RE: SSD 6626 – Darling Harbour Live North East Plot

I refer to Planning & Infrastructure's recent exhibition of an Environmental Impact Statement (EIS) for a Stage 2 SSDA seeking approval for the construction of the "North East Plot" within the Darling Harbour Live Development.

This submission comprises the City of Sydney's (the City's) comments on the proposed public domain, transport and built form issues associated with the DA.

SOUTH ELEVATION

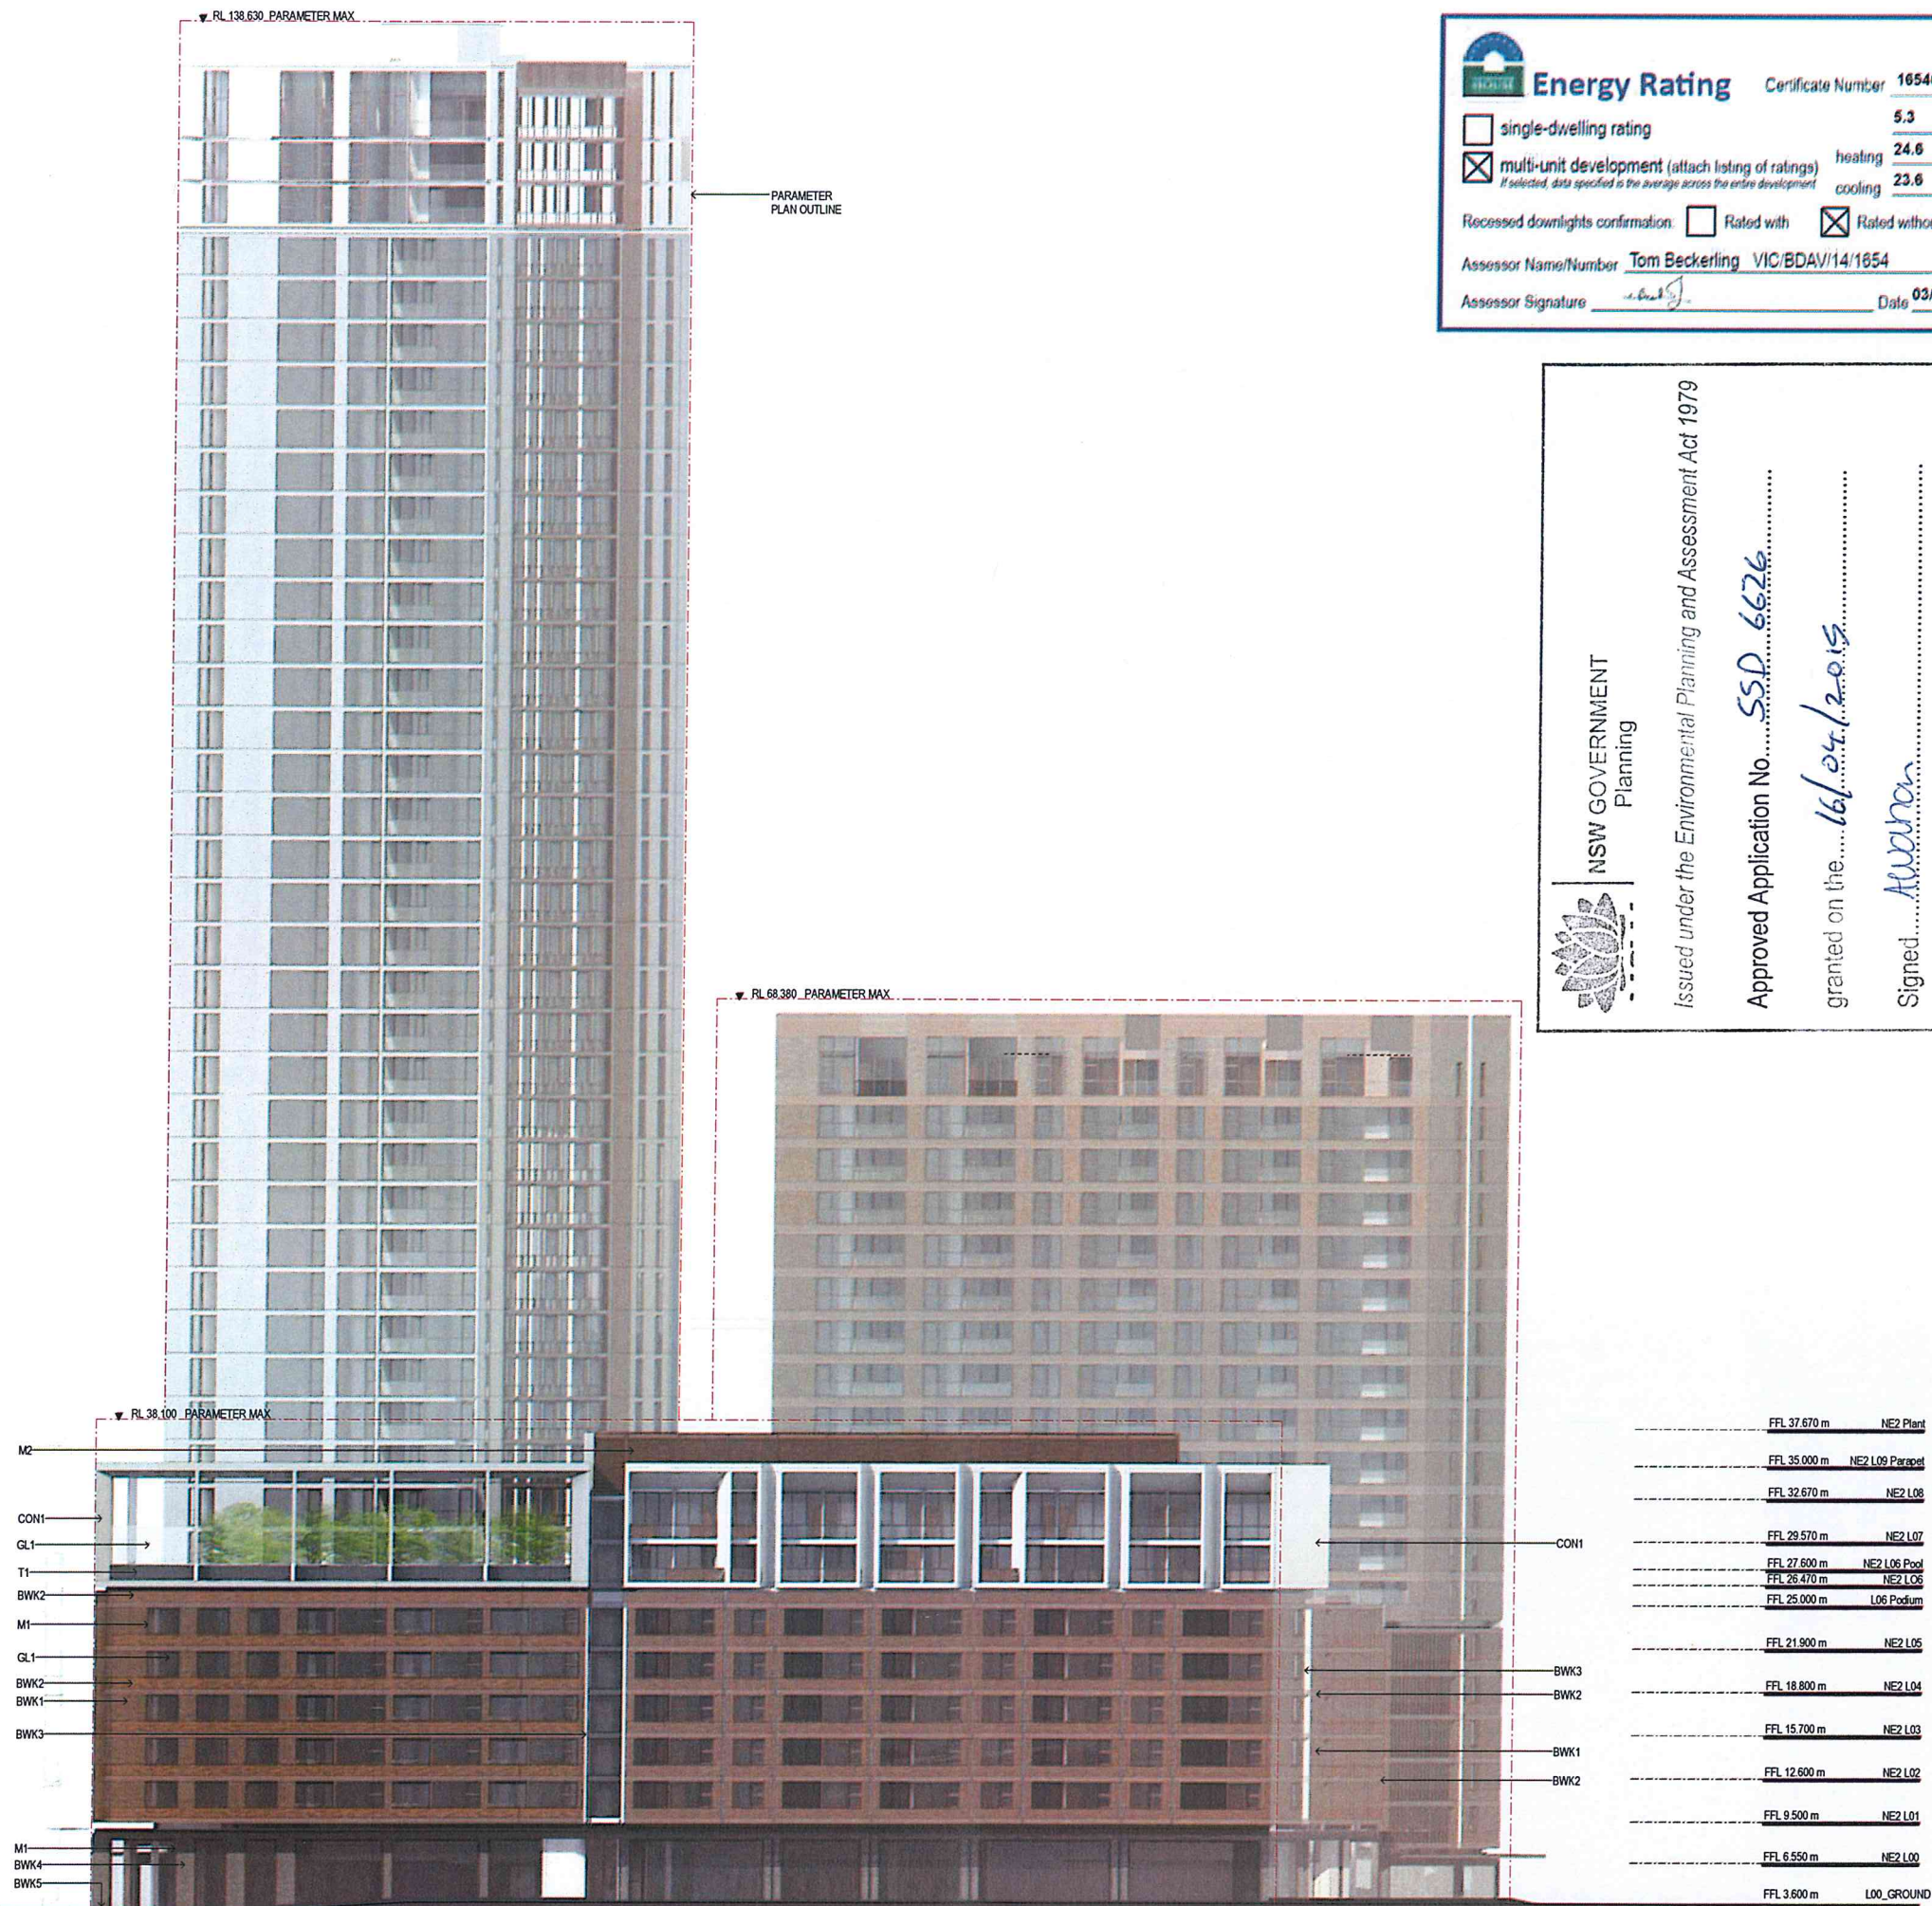
The City questions whether the transition between the podium and the towers is clear. There is a limited height horizontal re-entrant between the podium and towers. There is also a change in material on the external skin in the way balcony balustrades transition from brickwork to glass above the podium. However, the City contends that the podium should be more clearly defined from the towers. One approach, although there are likely to be several, may be to reduce the appearance of the white coloured vertical fin walls within the podium to have the podium appear more horizontal generally. Another approach may be to increase the height of the re-entrant.
